**Application for Planning Permission for Works or Extension to a Dwelling**

**Development:** Conversion of attic space to habitable accommodation, single storey rear extension, external thermal insulation and horizontal cladding to external walls. Replacement windows and doors. Installation of photovoltaic panels to southern roof slope.

**Location:** 37 Bassett Road Bognor Regis PO21 2JH

PROPOSED GROUND FLOOR PLAN @ 1:100

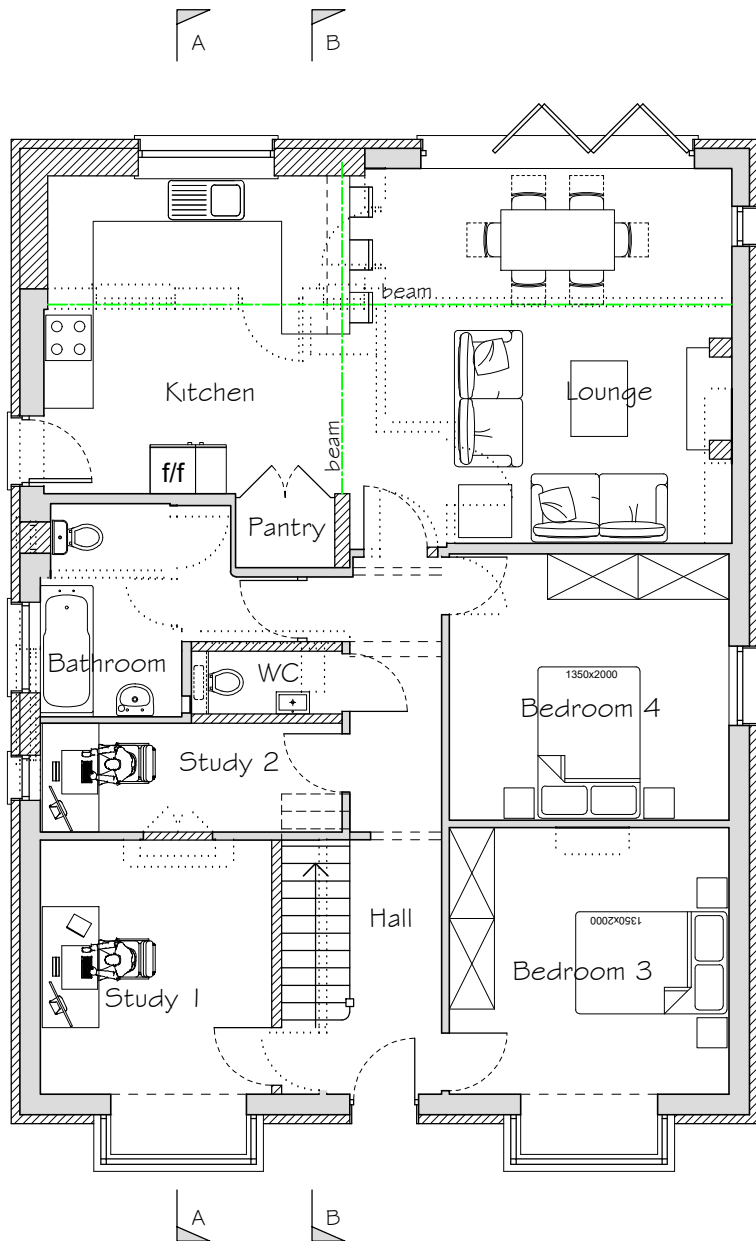
The kitchen door shown on the proposed ground floor plan is missing from the proposed east elevation, please review and amend.
